TIERRA WEST, LLC

July 20, 2023

**RE: SAGE PLAZA AT 1125 SNOW VISTA BLVD. SW
EROSION AND SEDIMENT CONTROL PLAN
RESPONSE TO COMMENT**

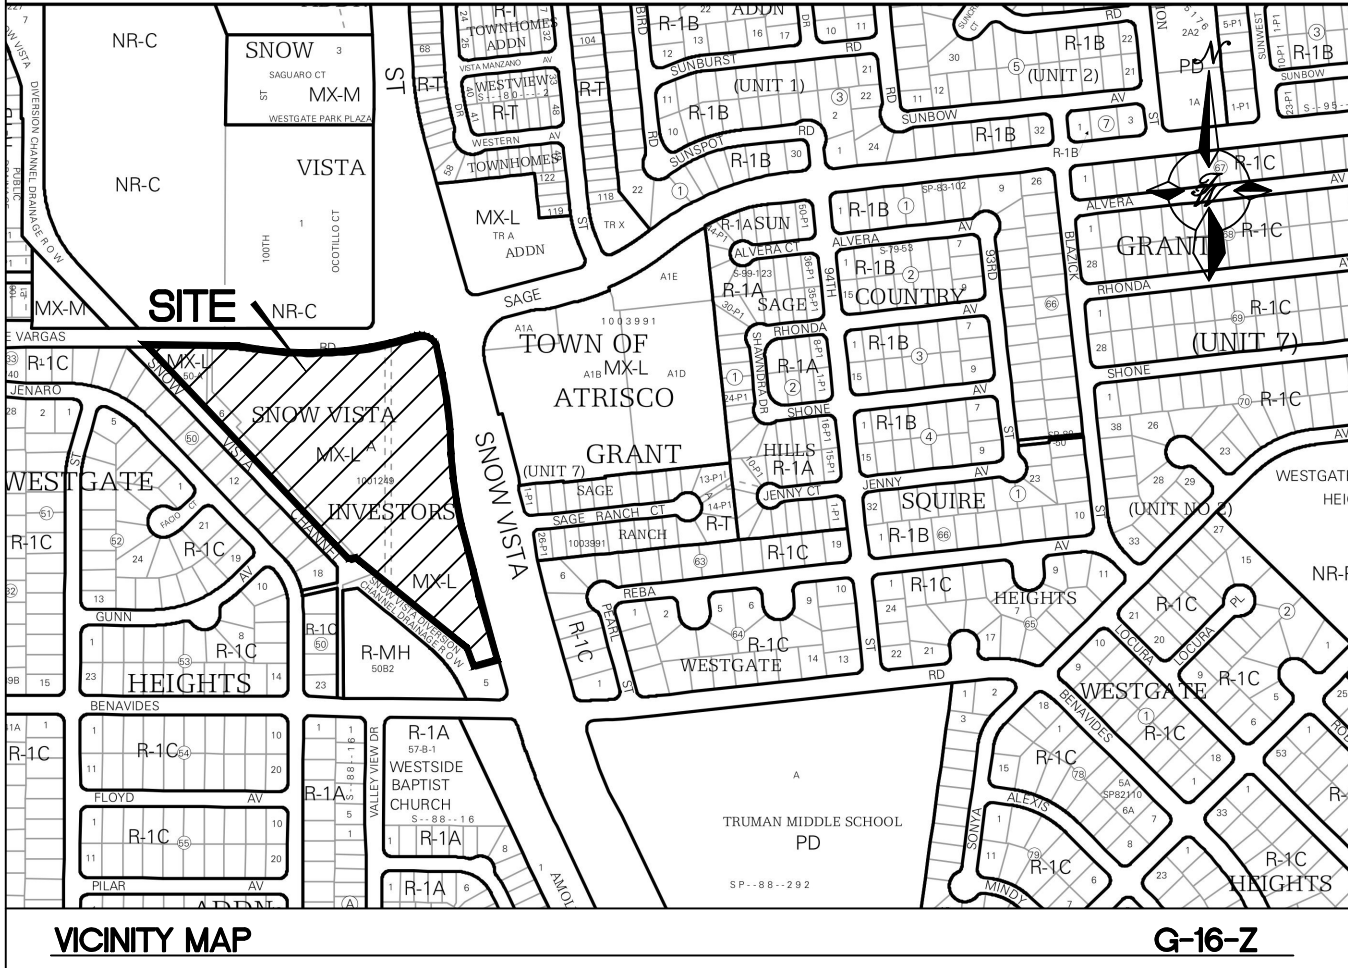
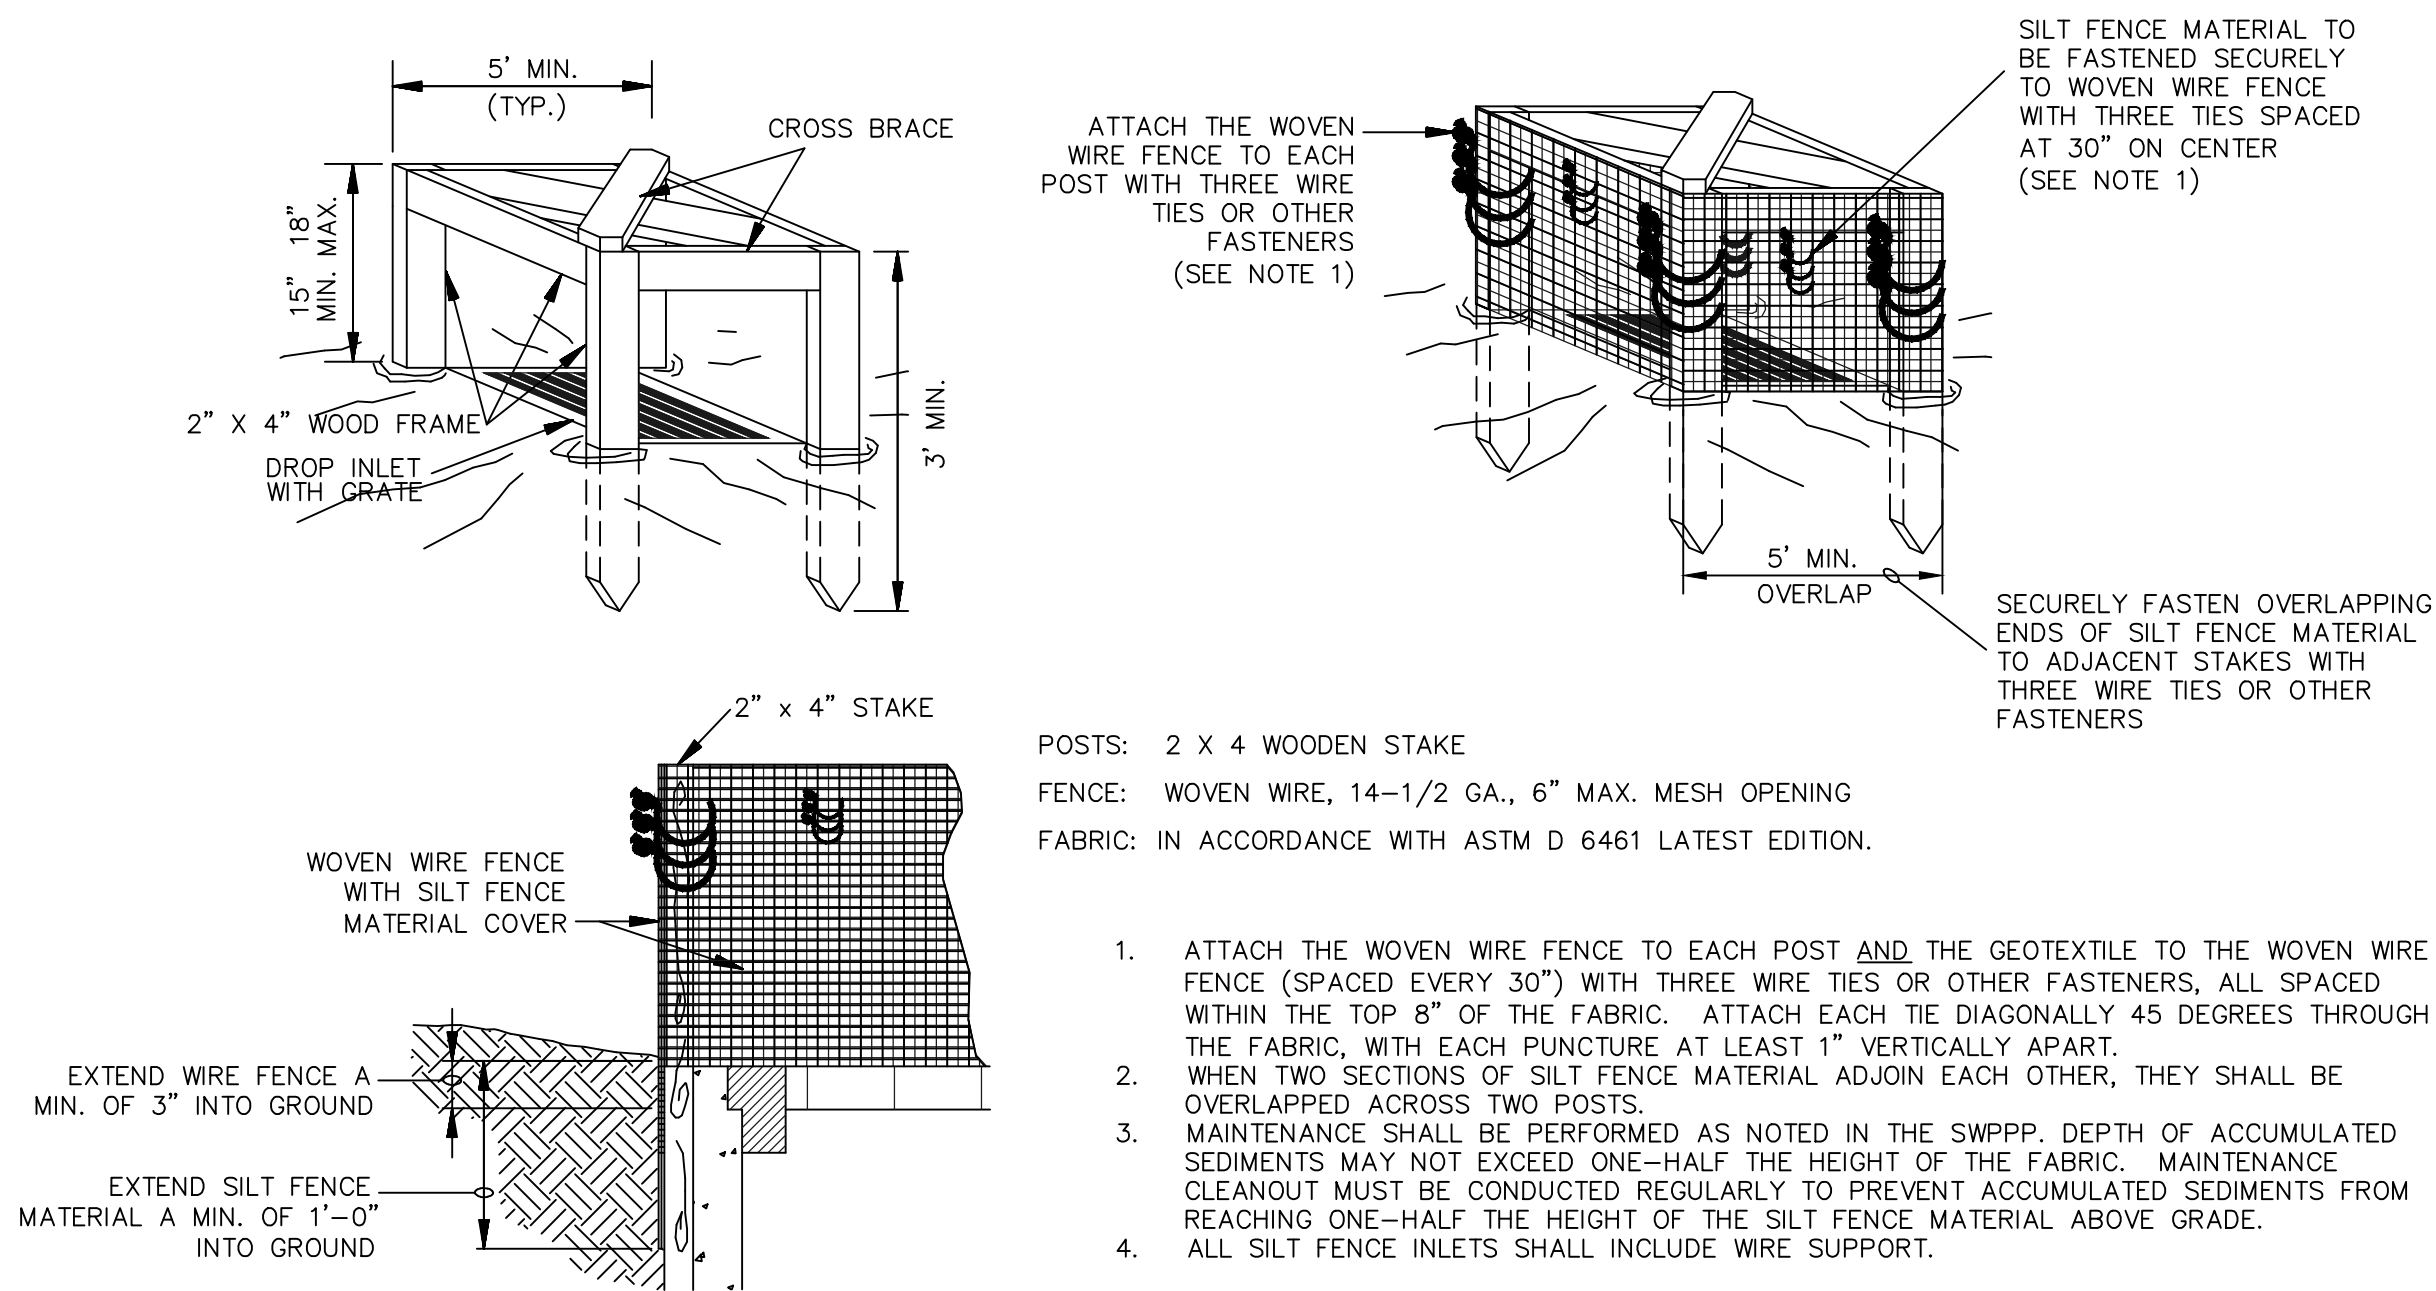
1. The NOI must be signed by a Trustee of Goodman Lawrence RVT.
Response: NOI was re-signed by a Trustee of Goodman Lawrence RVT and is attached.
2. The storm drain that is shown in the west part of the disturbed area hasn't been approved for construction with the subdivision. Please revise the ESC Plan in accordance with the G&D Plan approved by Hydrology for Subdivision Construction. Also, please revise the limits of disturbance to preserve more existing vegetation.
Response: Storm drain has been approved by hydrology and is attached. The limits of disturbance were updated as well.
3. Update the engineer's stamp date each time the plan is changed.
Response: Acknowledged.
